Appeal Decision

Appeal Ref: APP/R5510/W/21/3279874

Neyland Court, Pembroke Road, Ruislip HA4 8NQ

- The appeal is made under section 78 of the Town and Country Planning Act 1990 against a failure to give notice within the prescribed period of a decision on an application for planning permission
- The appeal is made by Anslip UK Limited against London Borough of Hillingdon.
- The application Ref 76364/APP/2021/1569, is dated 19 April 2021.
- The development proposed is the demolition of existing garage block and construction of detached building to accommodate new management office accommodation above replacement parking spaces.

| TITLE   | Proposed Site Layout                                                                   |             |          |

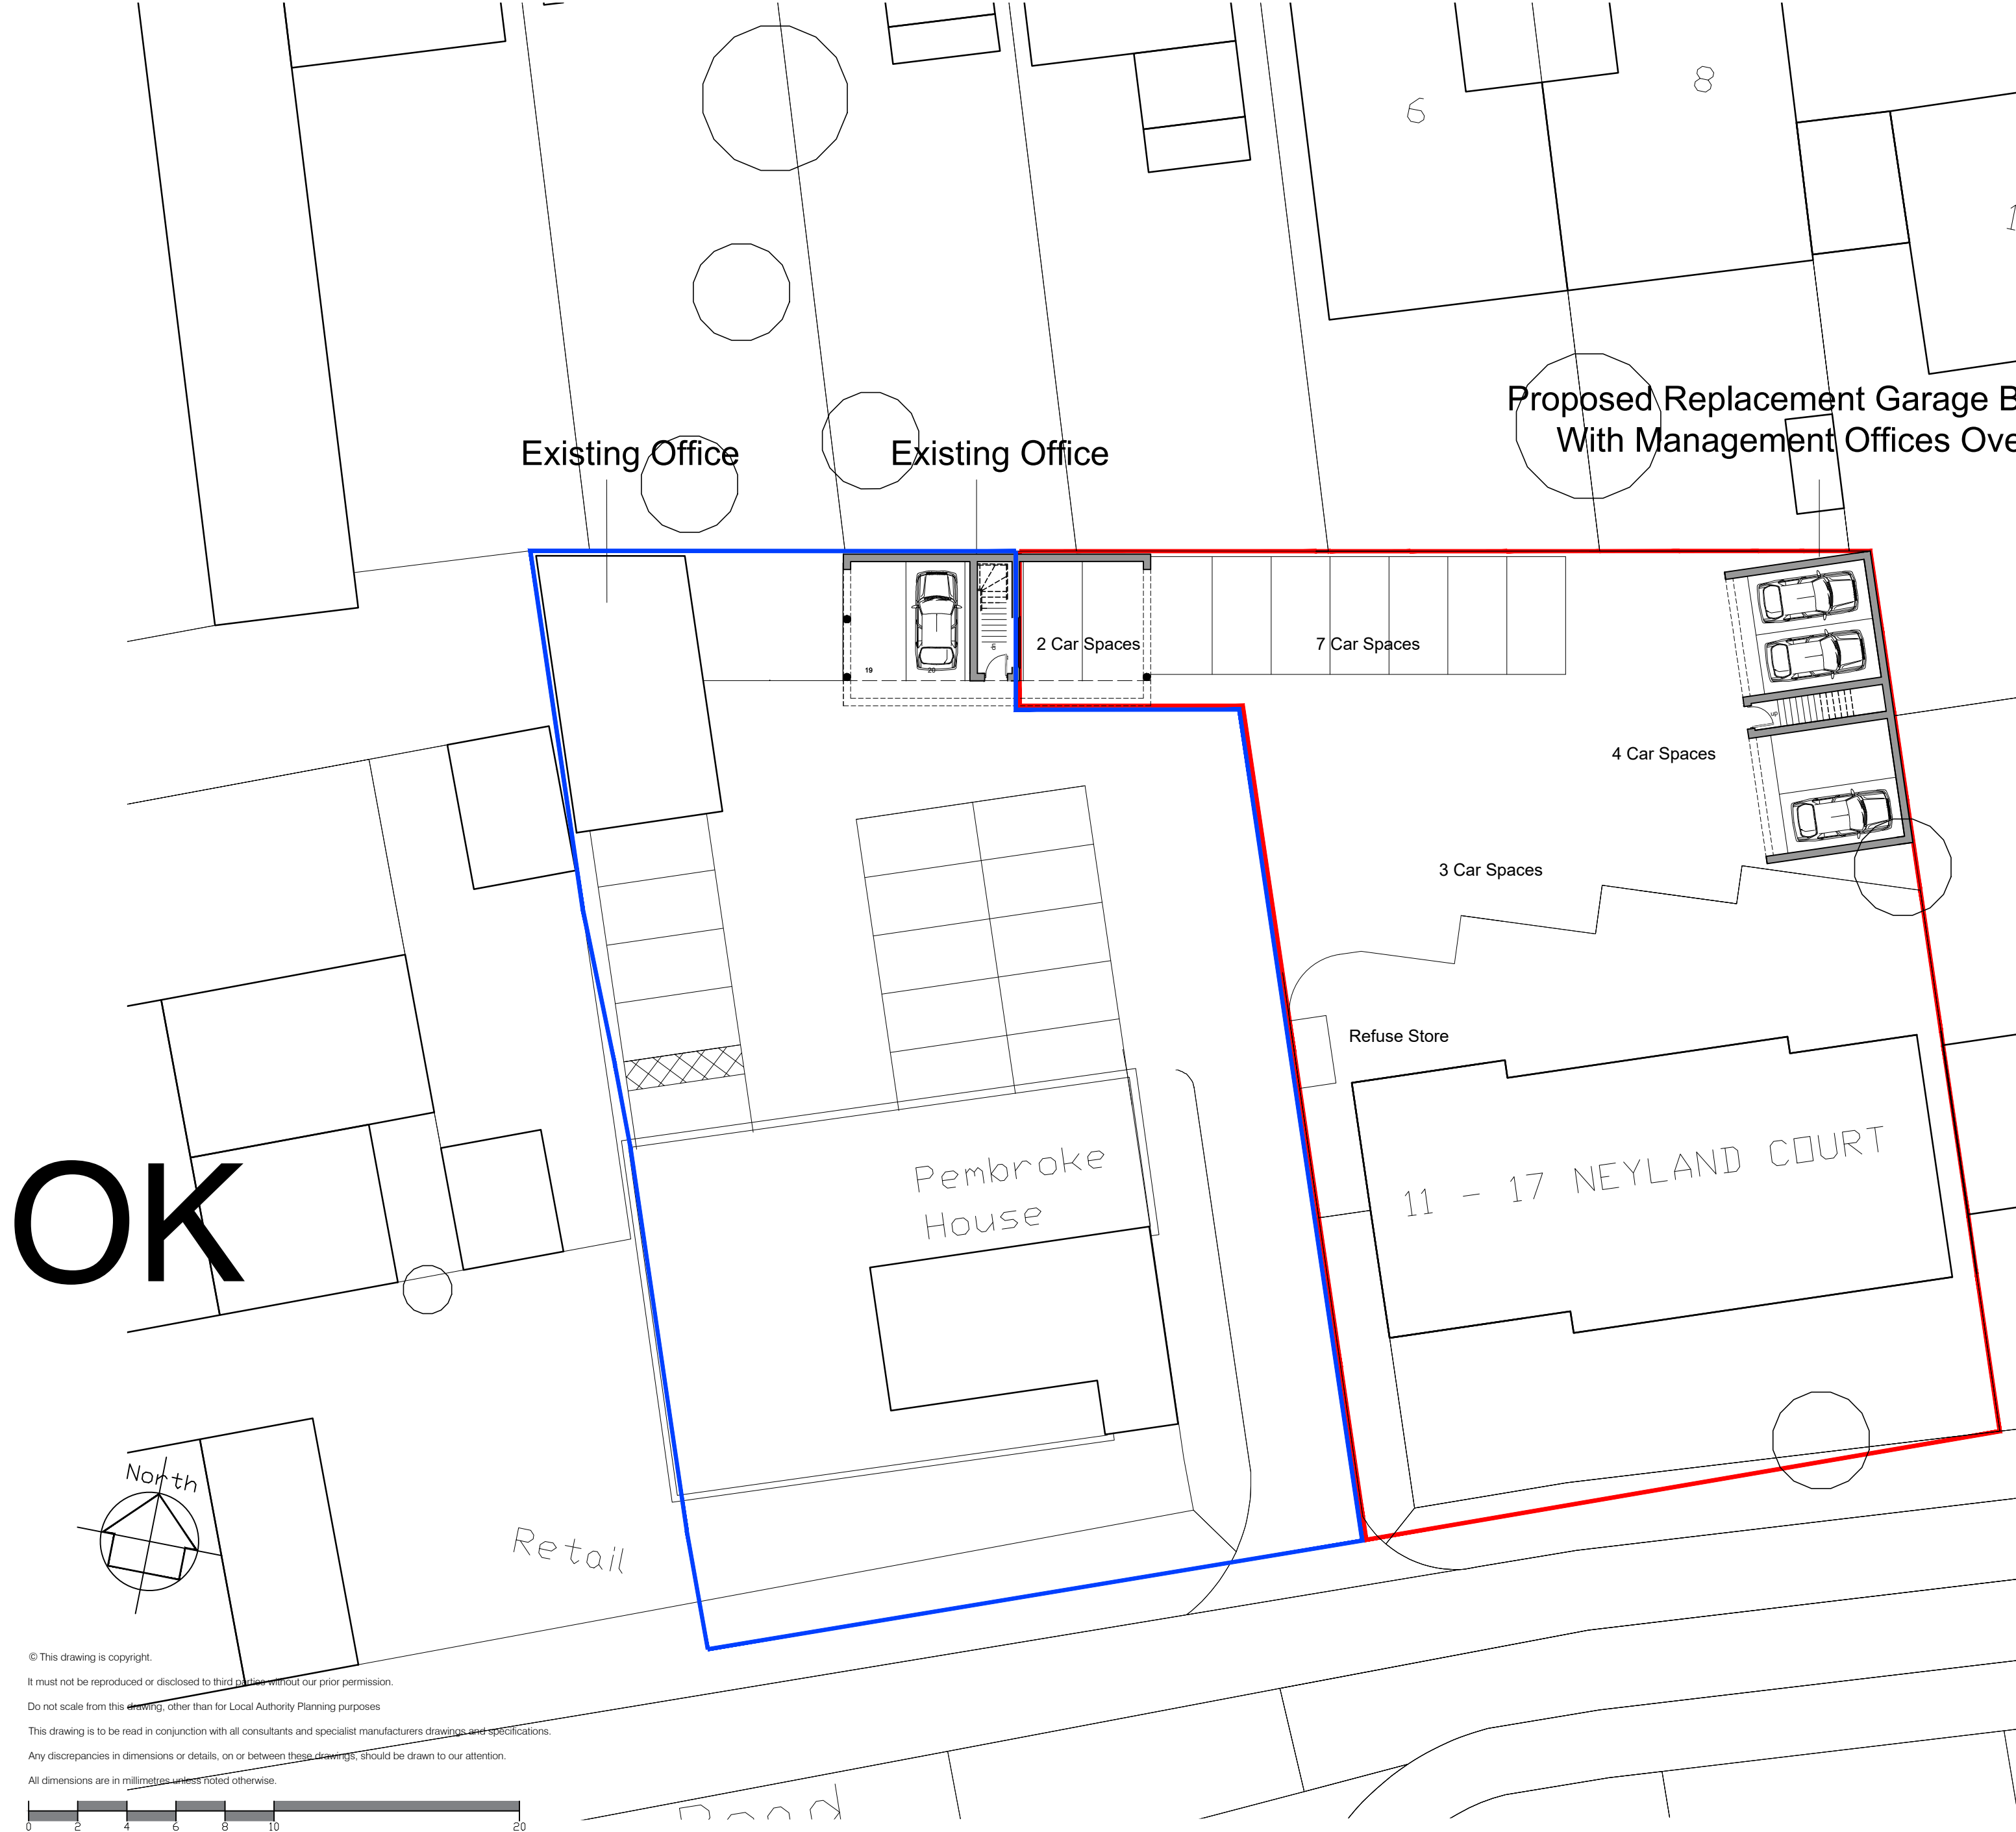
2. The appeal arises from the Council's failure to determine the application. Following the submission of the appeal against non-determination, the Council resolved that had the application been determined it would have been refused.
3. The submitted plans label the adjacent properties as 21 Pembroke Road, 8 and 10a Brickwall Lane, the Council details that this is incorrect and my observations on site confirm this. The correct properties labels are 19 Pembroke Road, 6a and 8 Brickwall Lane respectively.

Proposed - Elevations

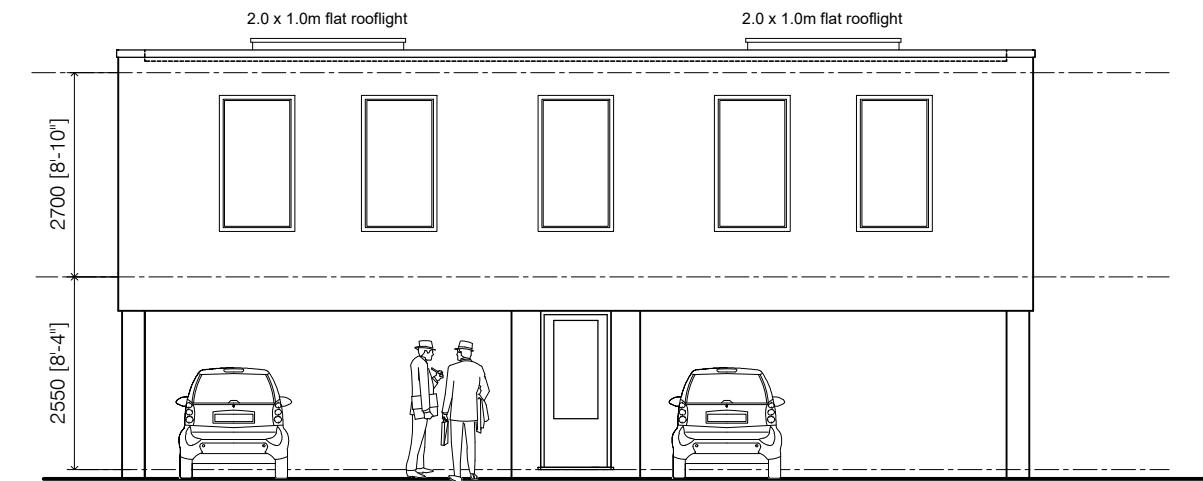
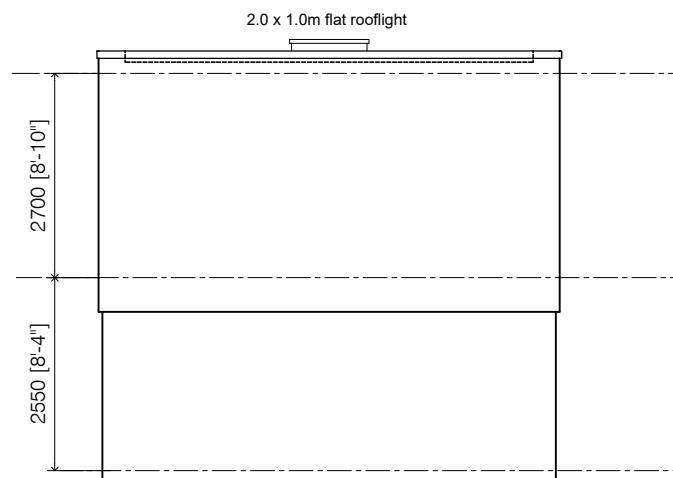
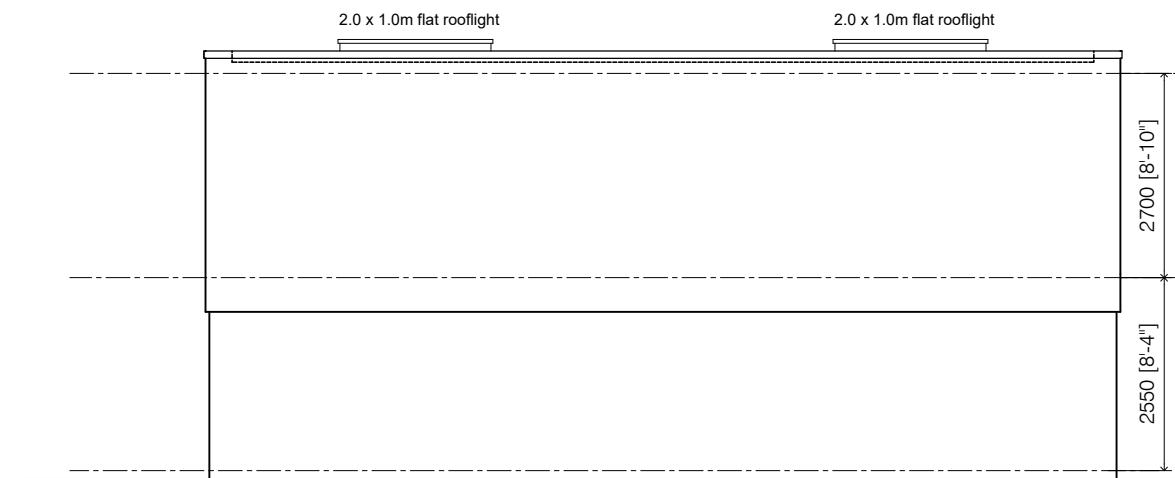
7. The appeal scheme would replace the garage block with a two-storey building occupying a similar footprint and location to include car parking to the ground floor and office accommodation to the first floor. The first floor presents a blank and featureless brick wall to the side and rear elevations facing the adjacent residential properties.

8. As a result of the featureless elevation situated at some height and being of notable width, the proposed building situated in close proximity to the neighbouring dwellings and rear gardens, it is my planning judgement that the appeal scheme would have an overbearing impact on the residents using the adjacent gardens and harm the outlook enjoyed by residents from the rear elevation of No.19 and Nos.8 and 6a.
